Norfolk Vanguard Offshore Wind Farm

Applicant Response to Broadland District Council Local Impact Report

Applicant: Norfolk Vanguard Limited
Document Reference: ExA; LIR; 10.D2.4C

Date: January 2019
Author: Royal HaskoningDHV

Title:
ExA; ISH; 10.D3.1A
Location of Hornsea Project Three main compound

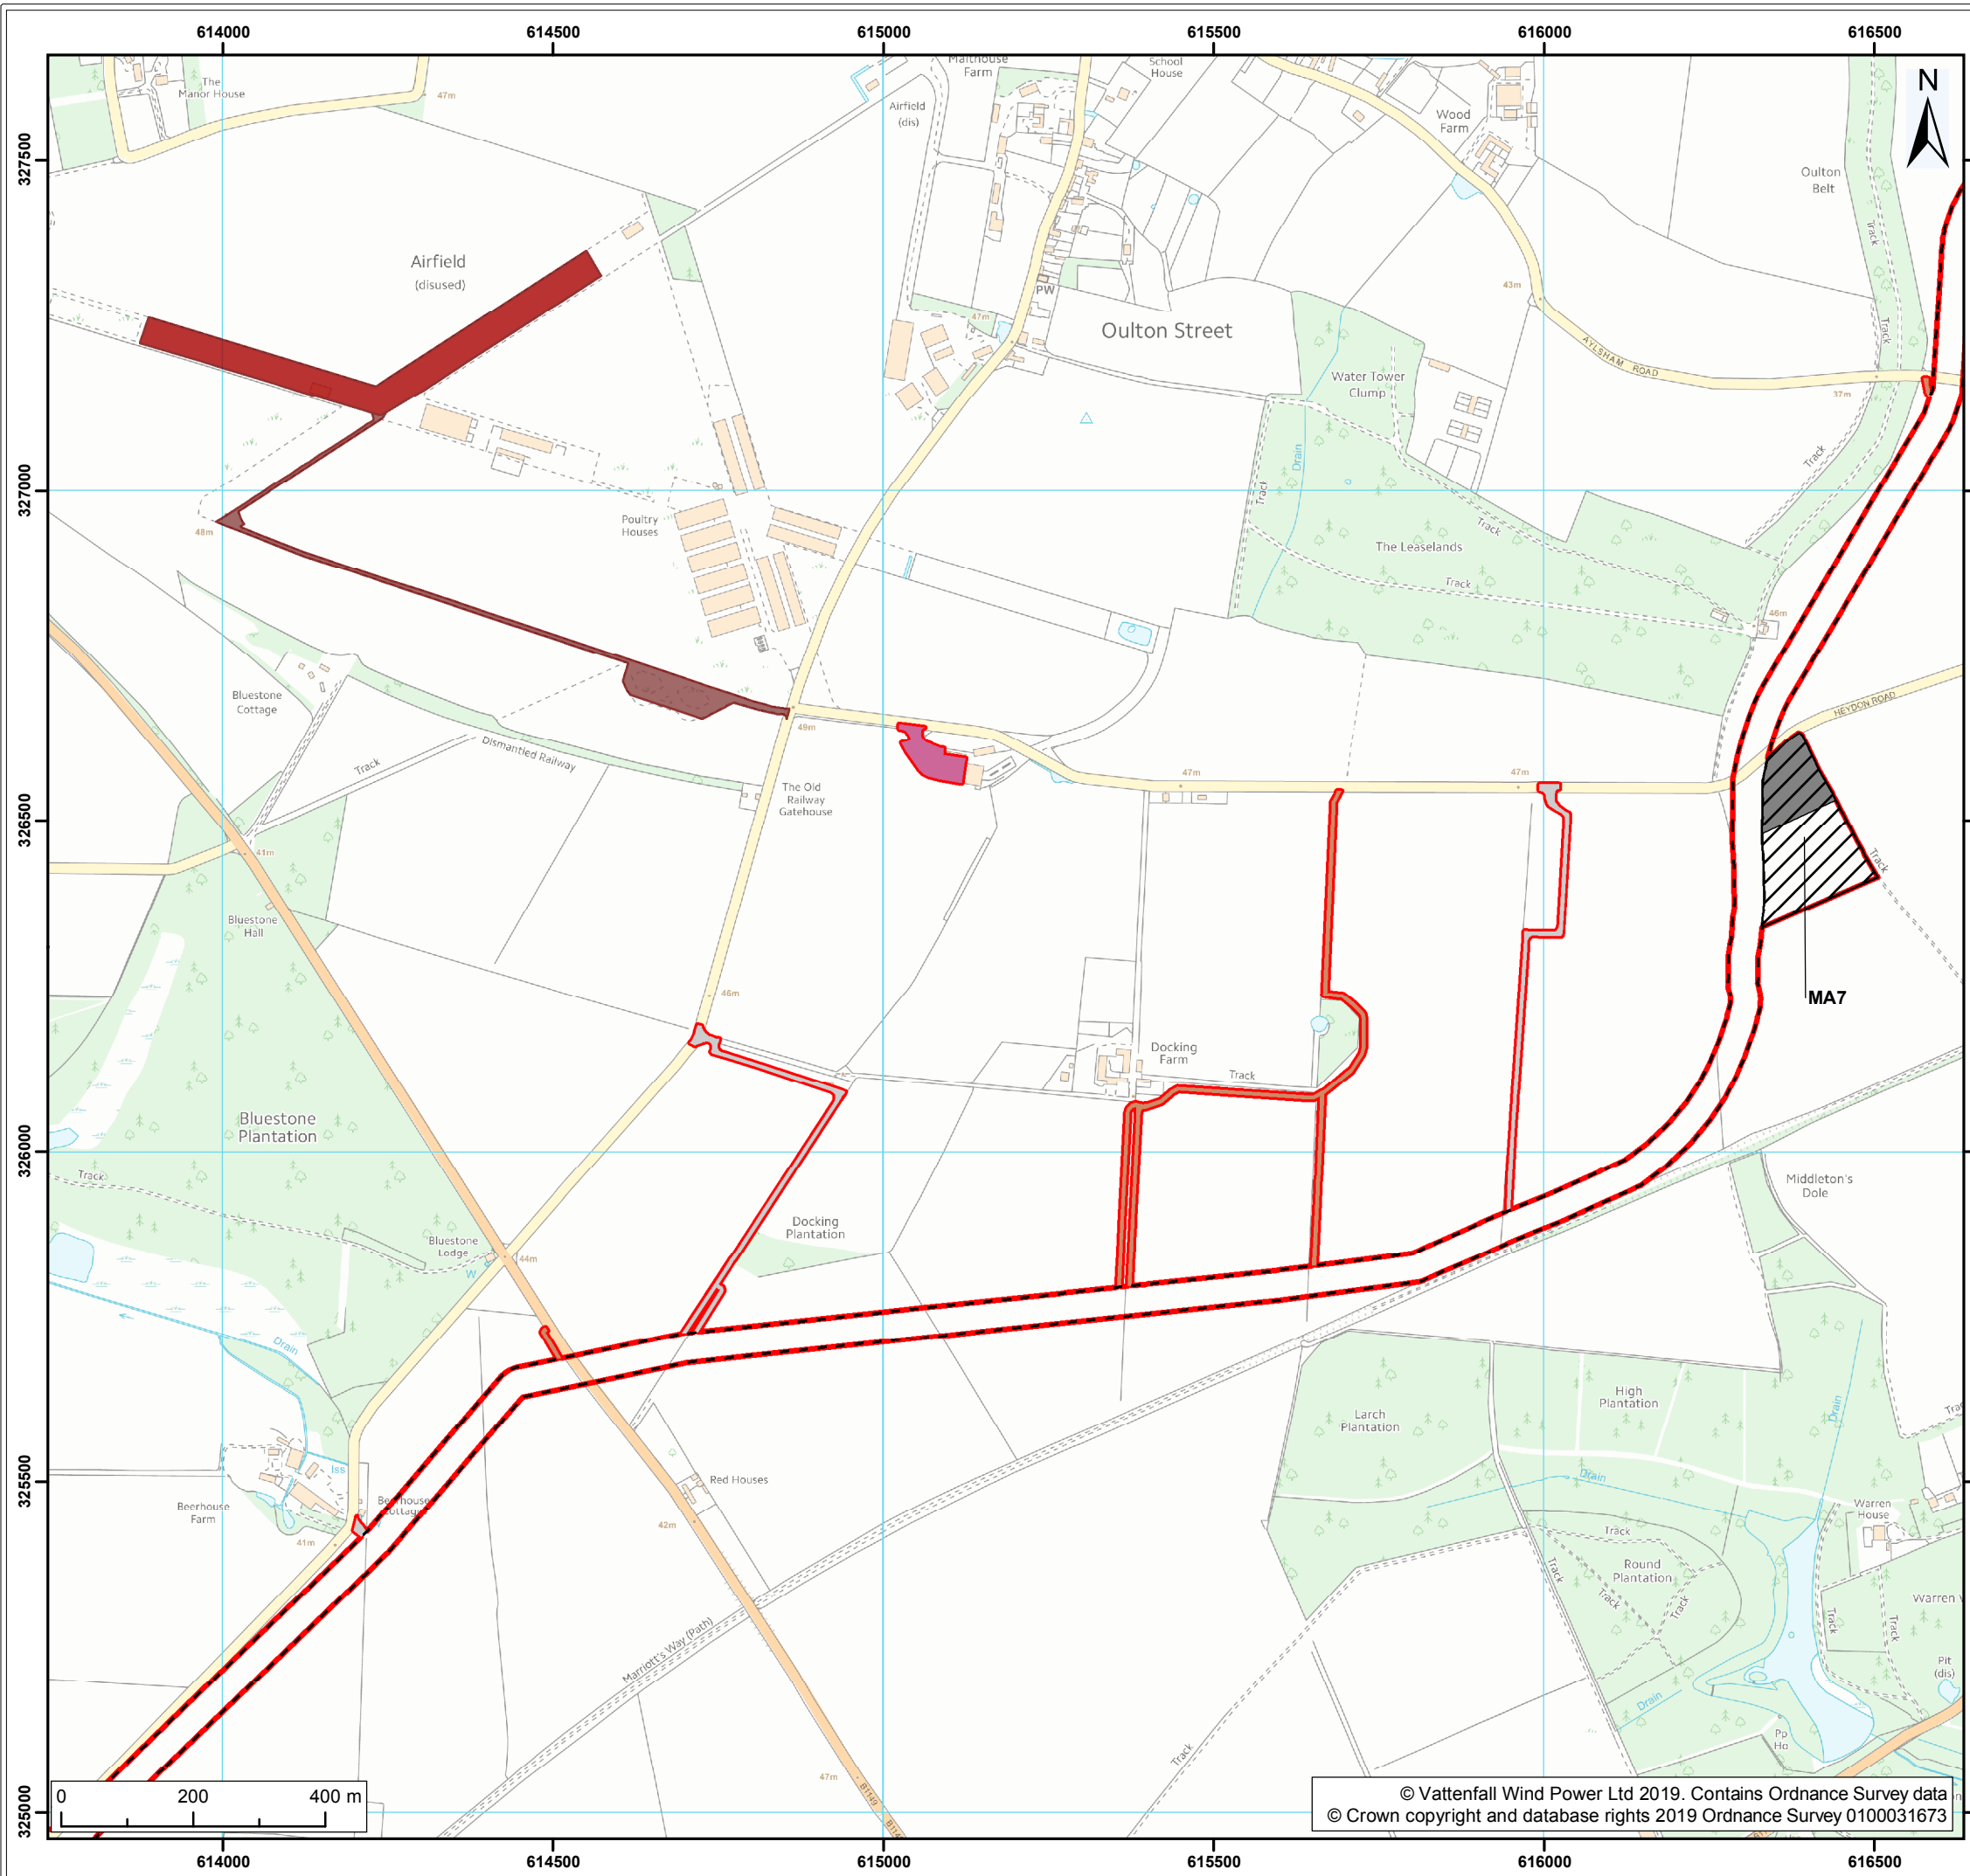
Broadland District Council Local Impact Report	Applicant's Response
<p>be considered. In this respect it is noted that Hornsea Three are proposing their main construction compound on part of the former airfield to the south west of the village of Oulton, in addition to the two construction compounds that Norfolk Vanguard are proposing in Oulton. Both operators are proposing to use The Street to connect to the B1149, which is a narrow country lane. There are concerns about whether the construction programmes will overlap and therefore cause significant disruption in the village and the surrounding area. Reference is made at para. 3.2 above to a previous planning application (ref: 20130860 and the subsequent appeal decision) for an AD plant on part of the former Oulton Airfield which was refused and dismissed at appeal on grounds that the proposed development would have an unacceptable impact on highway safety and convenience and be likely to result in material harm to the living conditions of residential occupiers of The Old Railway Gatehouse with reference to noise and disturbance.</p> <p>5.4 In addition the two cable corridors cross at a point north of Reepham and this has the potential to increase the visual and environmental impacts of the proposal in the locality of this intersection.</p>	<p>chapters (ES Chapter 19 – 31 for onshore). The CIA assesses potential cumulative impacts of the project with Hornsea Project Three and other relevant development proposals. The list of projects in the cumulative assessment was developed in consultation with and agreed with Norfolk County Council and submitted to Broadland District Council for approval prior to submission of the DCO application. The Applicant would refer to ES Chapter 5 Project Description (document reference 6.1.5), in particular map 5 of Figure 5.4. The proposed use of The Street at Oulton is required to access a single mobilisation area (MA7) located further east along Heydon Road. This access route is identified as Link 68 within the application. MA7 is only required to support the construction works in proximity to Oulton only, and is not a main works compound.</p> <p>The Applicant is continuing to work with Orsted to consider cumulative impacts in relation to construction traffic near Oulton. There is a SoCG submitted for Deadline 1 between Norfolk Vanguard Limited and Norfolk County Council (Rep1-SOCG-18.1) where traffic related matters are agreed or subject to further discussion.</p>
